**Application Reference:** 2024/0689

**Site Address:** 12 Lakeland Close, Cudworth, Barnsley, S72 8SL

This application seeks planning permission for the erection of single storey outbuilding to rear, and detached garage to side of 2 storey detached dwelling

DRAWING TITLE  
Garage Combined Plans

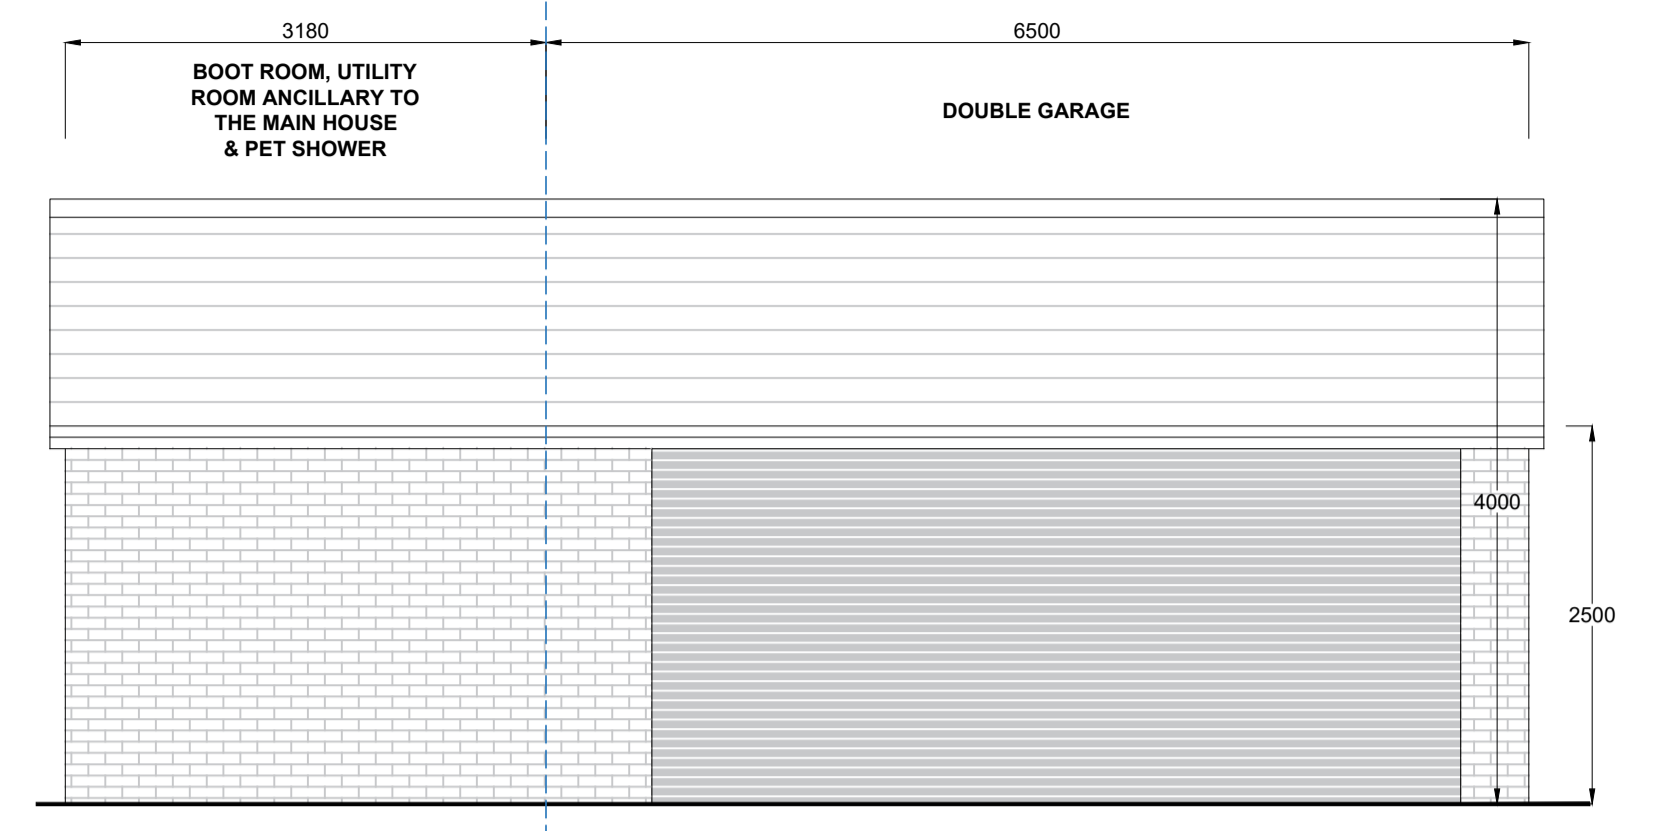
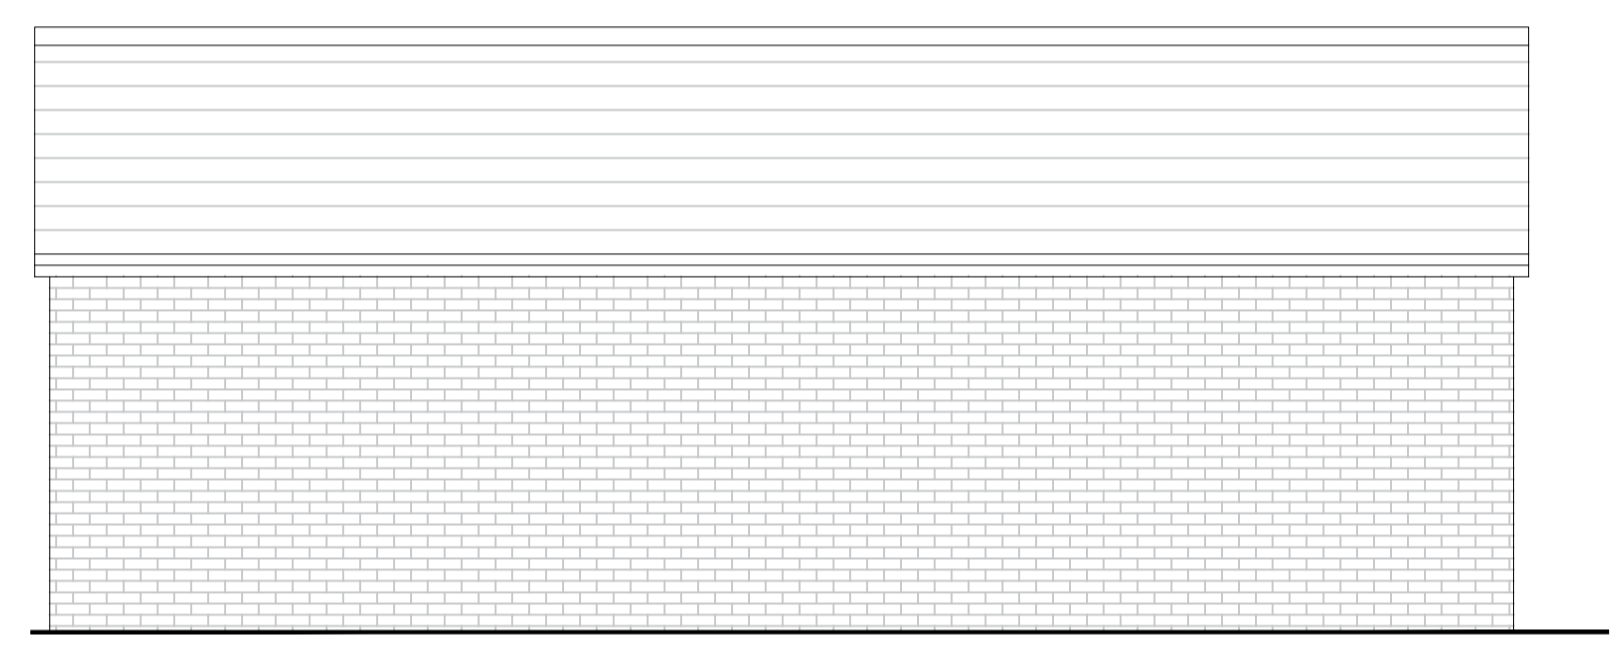
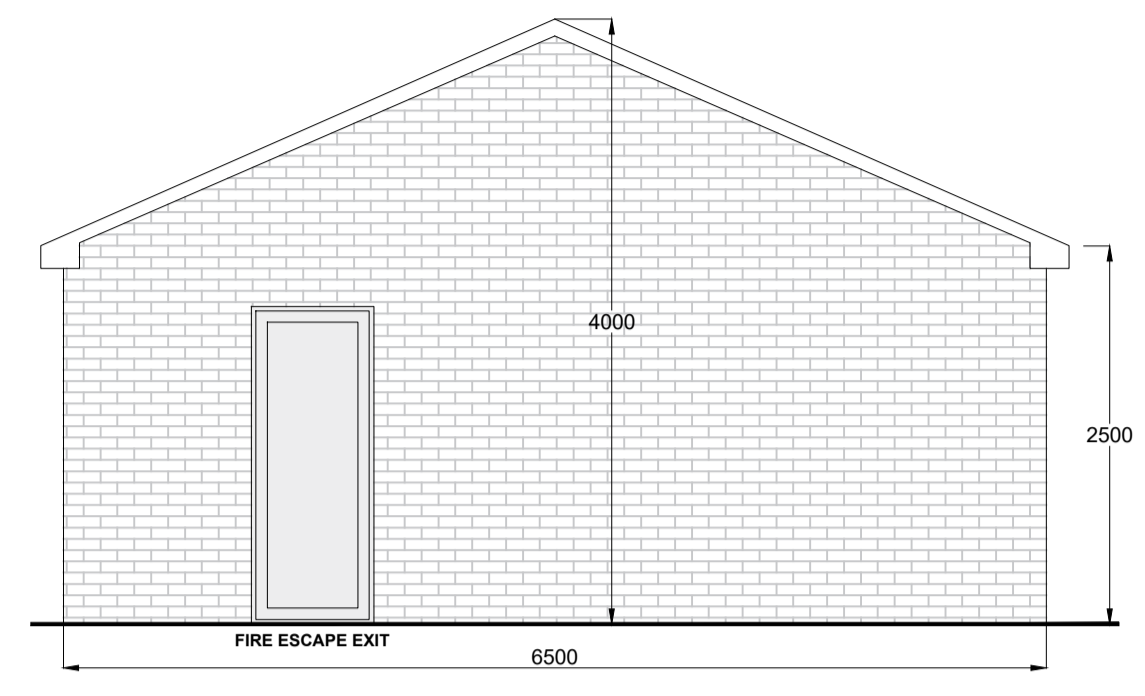
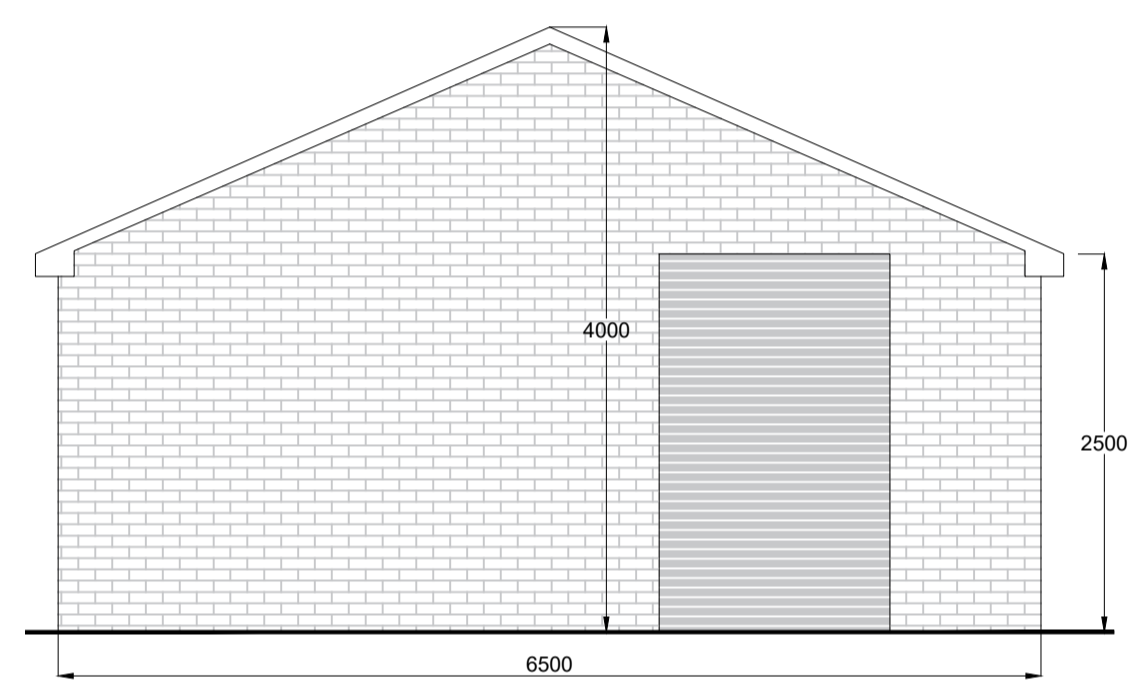
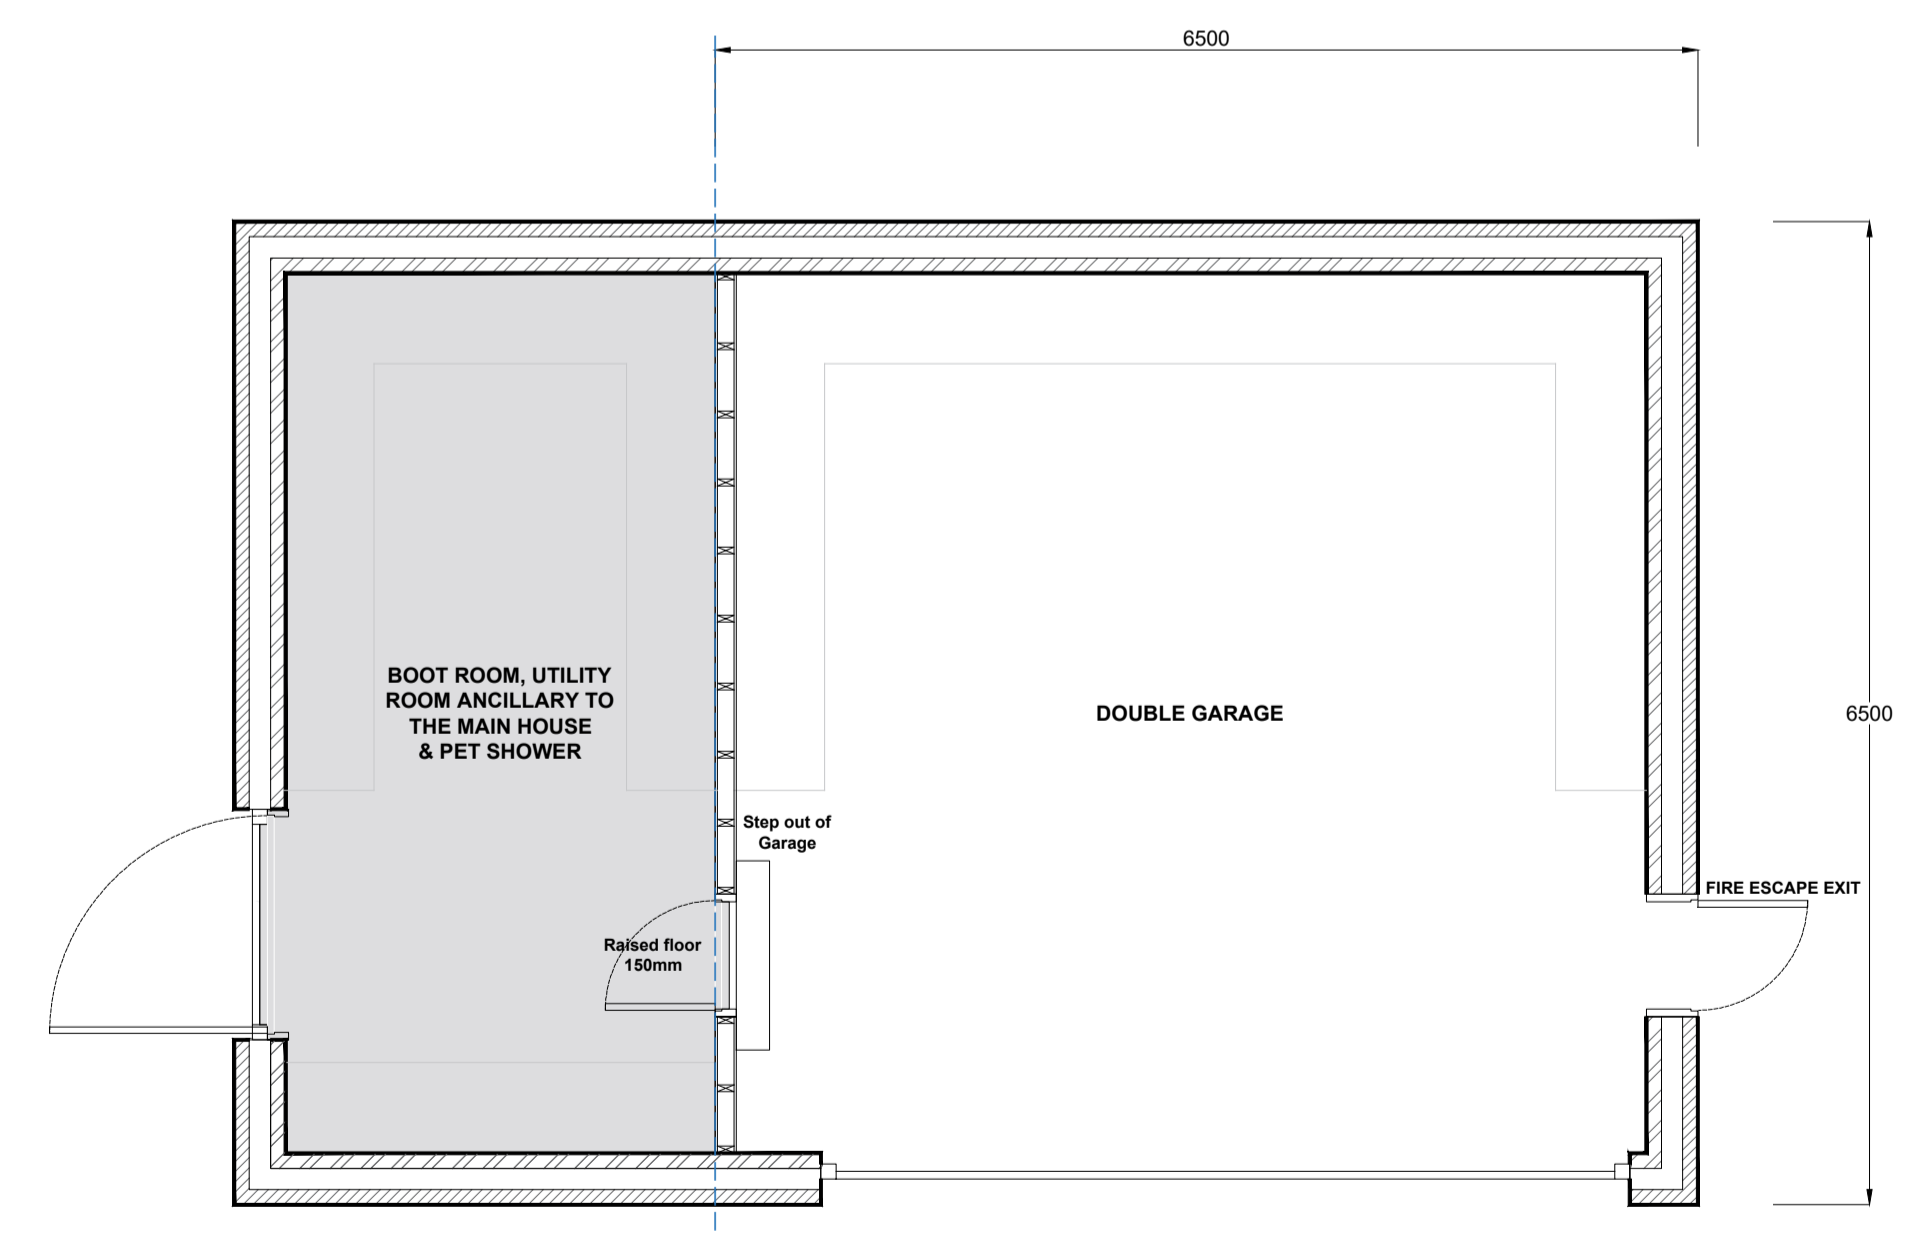
The application has been amended during the course of the application. The first part of the reduced size proposal is for a detached, single storey garage with an attached utility room located adjacent to the eastern elevation of the dwelling but projecting by approximately 6.38m beyond the line of the front elevation of the dwelling, The whole structure would be approximately 6.5m in width and 9.7m in length, and is proposed to be constructed of brick. Individually the double garage, with a single large garage door has an area of approximately 42 sqm whilst the utility room would be approximately 21 sqm. The combined roof would be dual pitched roof and has an approximate eaves height of 2.5m and a ridge height of 4m. The garage would feature a single garage door of approximately 5.35m wide by 2.35mm high and be located on the front elevation looking towards the house and driveway. The rear side elevation would look into the rear garden and feature a smaller entrance door/shutter whilst the front elevation facing Lakeland Close would be a blank brick elevation, no other windows are proposed.

The garage is also of a substantial size, but again site characteristics mean that it does not appear overly dominant. The existing dwelling is large and the garage would be positioned towards the eastern elevation behind the building line of the adjacent dwelling at No.10. Whilst the garage including the utility room also exceeds the recommended size for outbuildings, in similarity with the outbuilding, whilst SPD guidance remains important, the garage's scale is proportionate in relation to the host dwelling and front garden, and whilst it exceeds SPD guidance, it does not introduce significant negativity. With some of the proposed garage being located behind the front elevation, rather than all on front of it, and with a significantly high front boundary treatment, on this specific occasion and despite exceeding the SPD guidance, the proposed garage would be of a satisfactory scale and would have a limited effect on the design and character of the dwelling or the street scene. However, a condition is recommended so it remains ancillary to the main dwelling.

There is potential for the garage to have a negative impact on the amenity of neighbouring dwellings, particularly for the dwellings whose rear gardens back on to the application dwellings. With the adjacent neighbour of No.10, there would be less concern over impact as the dwelling sits at a 90-degree angle to the application dwelling, and the proposed garage would be located adjacent to their garage, and first floor extension above. Despite the height of the garage, it would not be expected to have anything more than insignificant impact to their amenity, potentially only overshadowing their garage and a side entrance door. Returning to the neighbouring dwellings which back on the location of the garage, the garage would be higher

than the existing fence but remaining as a single storey , and one at a reduced height than what was originally consulted on, with no objections received, there should not be any significant impact to the light levels of their rear gardens. There may be some impact to their outlook, but their current outlook is of the application dwelling, a caravan or its driveway. Because of some potential impact, the proposal has been consider as having a modest impact on neighbouring amenity.

- The eaves height, ridge height, and area of both the proposed garage and outbuilding have been reduced in amended plans. Additionally, the garage has been separated into a double garage, with an enlarged garage door, and an attached utility room.
